From: Sue Howell
Sent: 03 October 2018 16:54
To: Planning.Responses
Cc: Michael Eastham
Subject: FW: Planning application Ref: A/38/18/RES - Manor Nursery Site, Angmering

From: Sue Howell
Sent: 26 September 2018 12:19
To: Planning.Responses
Cc: Michael Eastham
Subject: Planning application Ref: A/38/18/RES

Further to submission of application A/38/18/RES I have viewed the documentation LLD1275-LAN-SCH-001 Rev 01 and plans LLD1275-LAN-DWG-201-204 detailed planting plans and can advise that the scheme proposed is comprehensive, detailed and suitable for situation having a varied and appropriate planting mix proposed with a good palate of both evergreen and deciduous trees and shrubs. The trees proposed are sufficient in height to provide instant impact whilst still being an appropriate size to aid establishment.

Description of Works: Approval of reserved matters following outline consent A/51/14/OUT relating to appearance, landscaping, layout & scale for demolition of the existing Manor Nursery Garden Centre & hard standing & redevelopment for 32No. dwellings with associated access, public open space & landscaping.

Drawing No	Revision
LLD1275-LAN-DWG-201	02

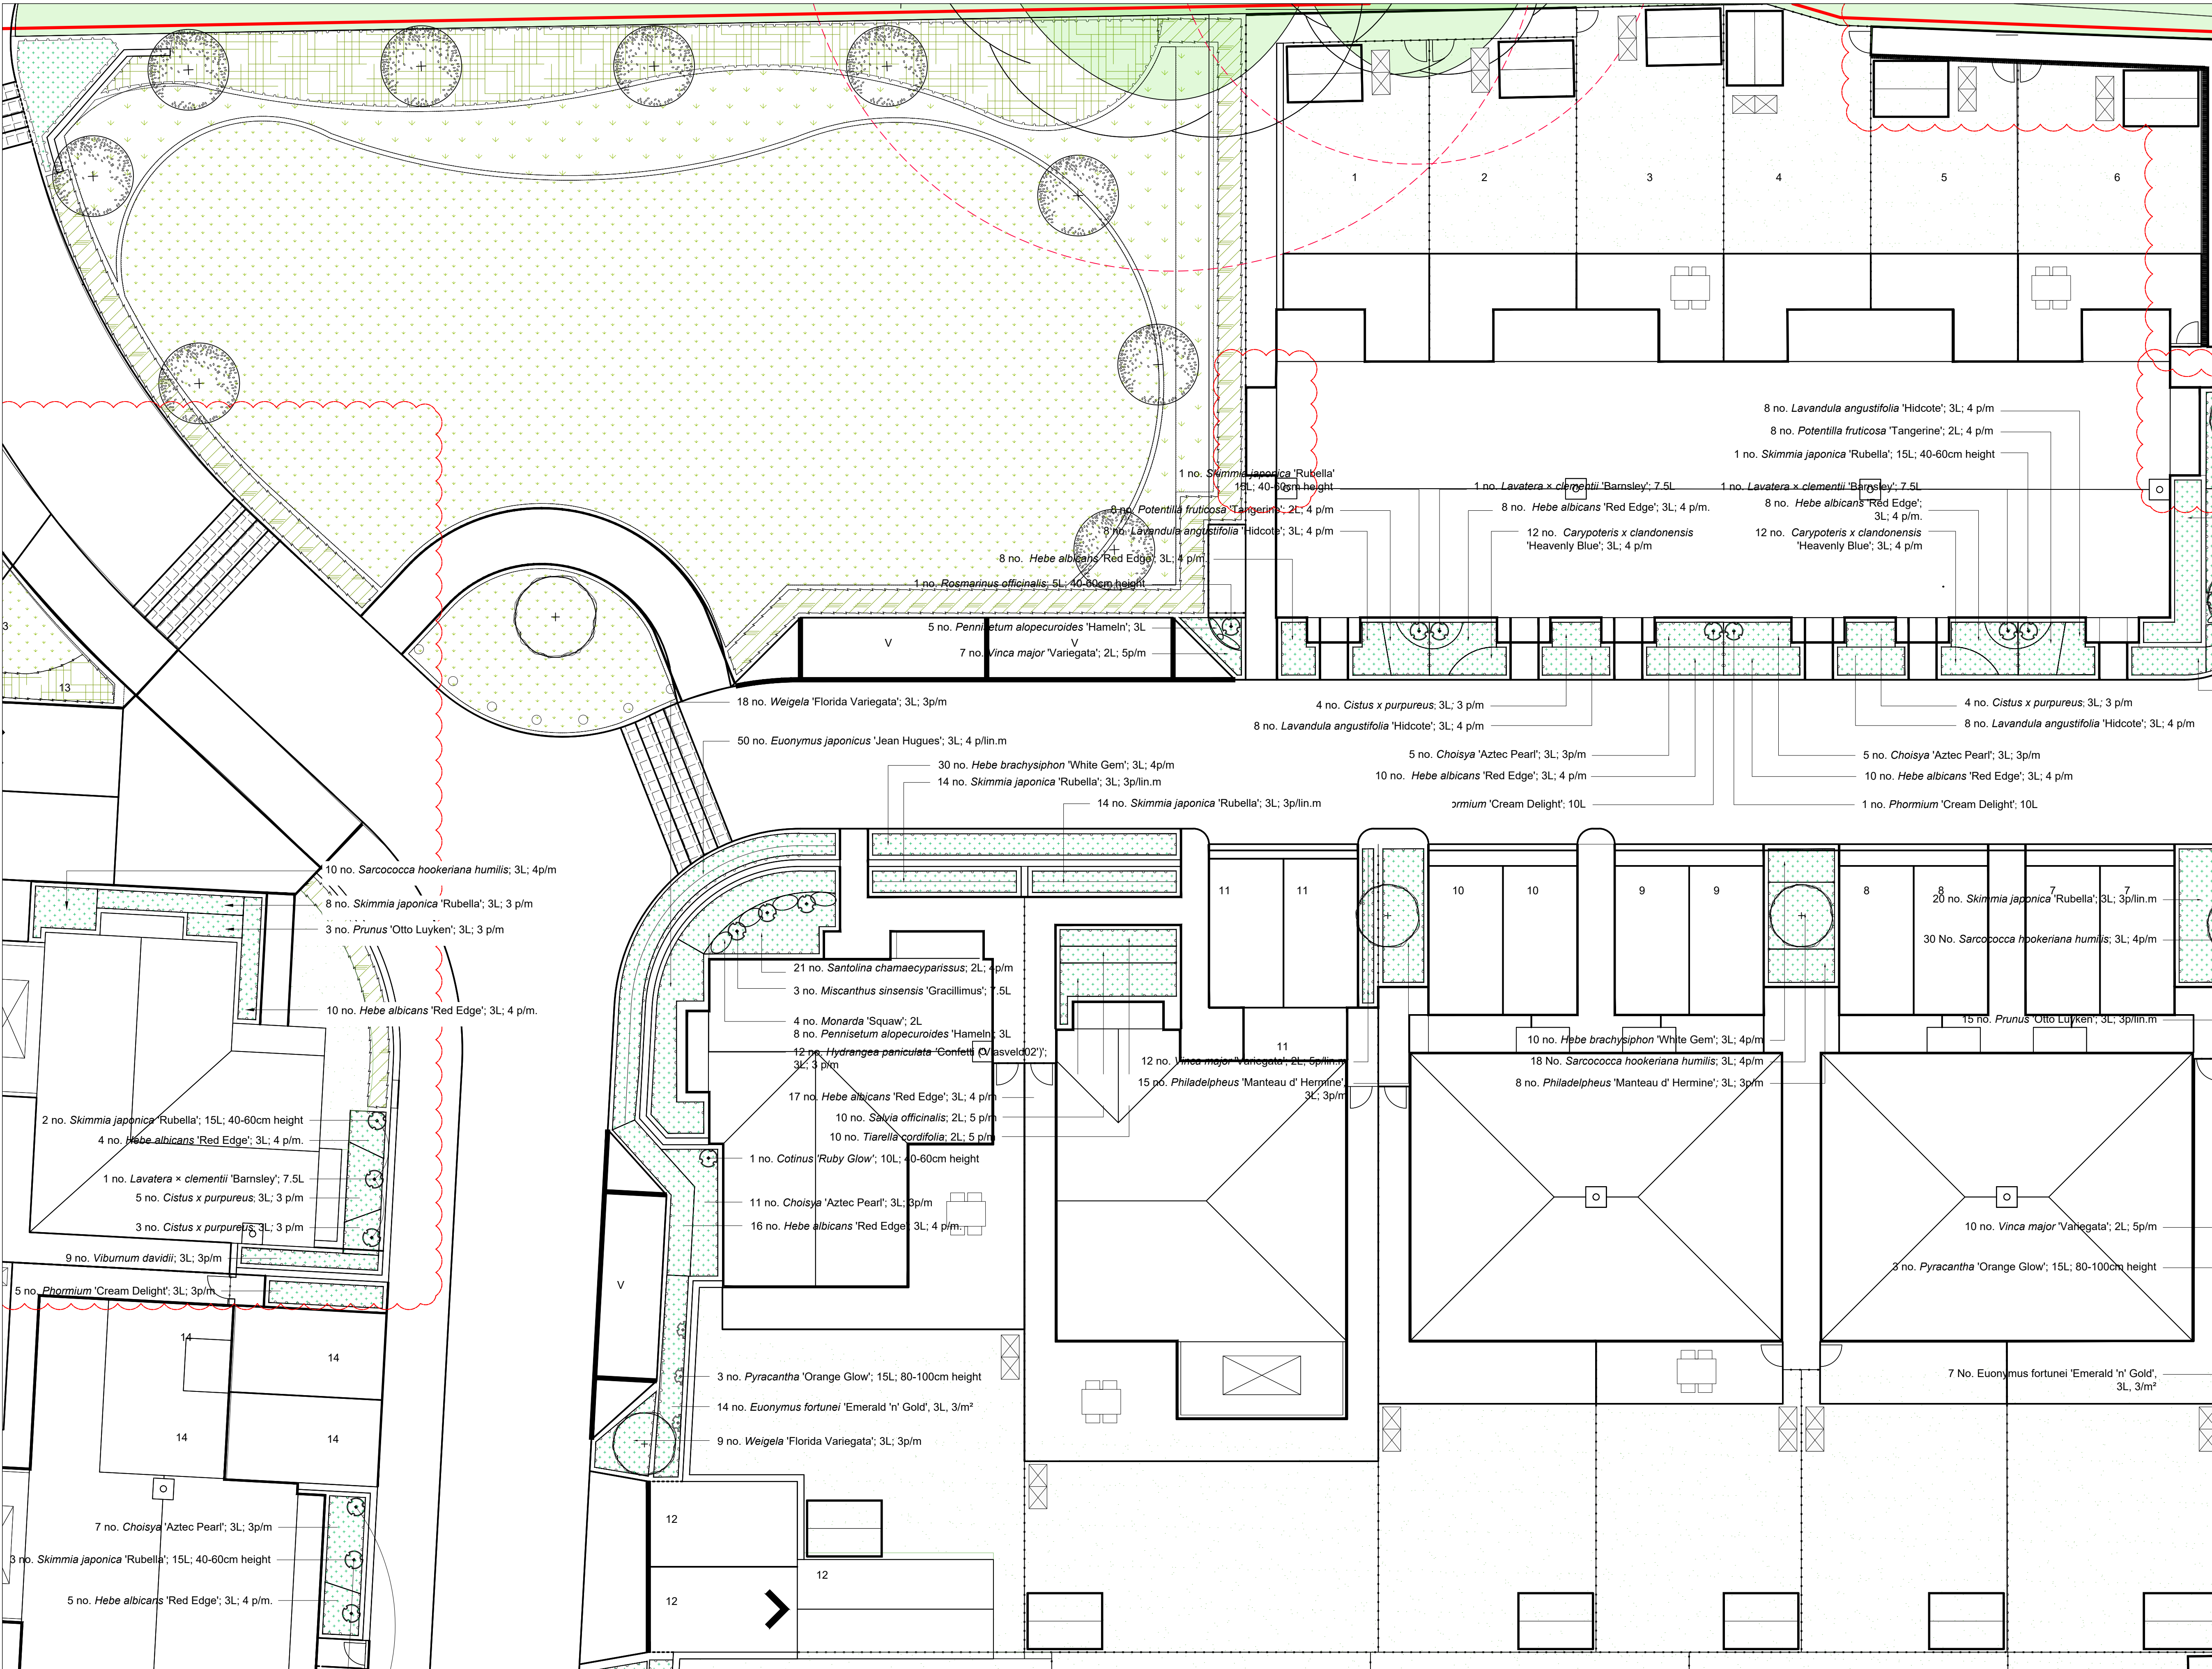
The plans detail existing trees and measures proposed for their retention and protection to secure their ongoing longevity.

We would therefore advise that I would recommend the approval of reserved matters on this application A/38/18/RES following outline consent A/51/14/OUT.
